Our Ref: BN/5/18/PL
Your Ref:

Town & Country Planning Act 1990 (as amended)
Town and Country Planning (Development Management Procedure) (England) Order 2015
Application for Planning Permission

Development Refurbishment of existing gravel surface in car park with a 350mm layer of Type 3 stone covered with a permeable surface of either tarmac or block paving.

Location Barnham Community Hall Yapton Road Barnham

Below is a drawing identifying the car-park layout proposed.

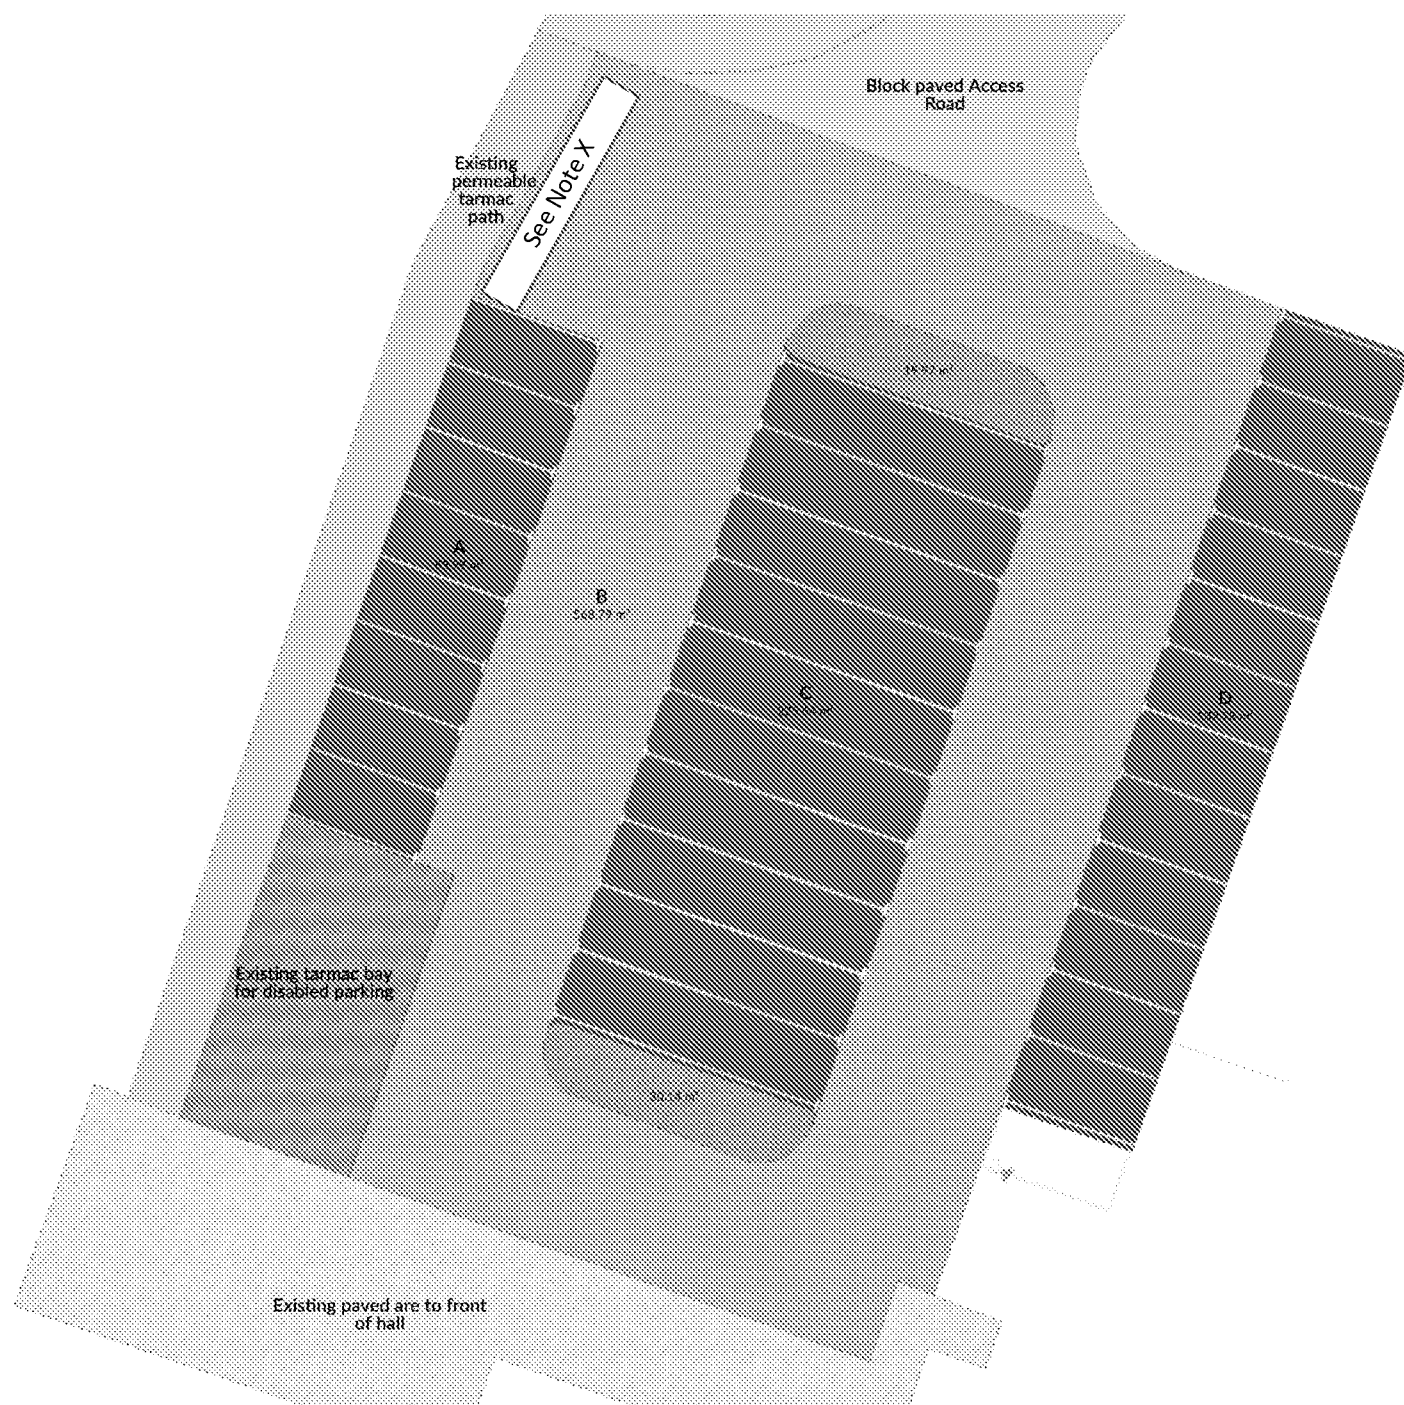
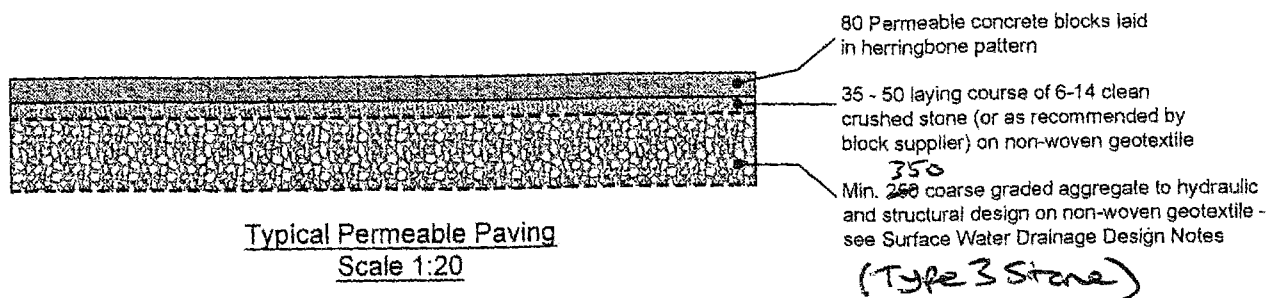
Please confirm if you wish to use tarmac or block paving for proposed covering of the car park.
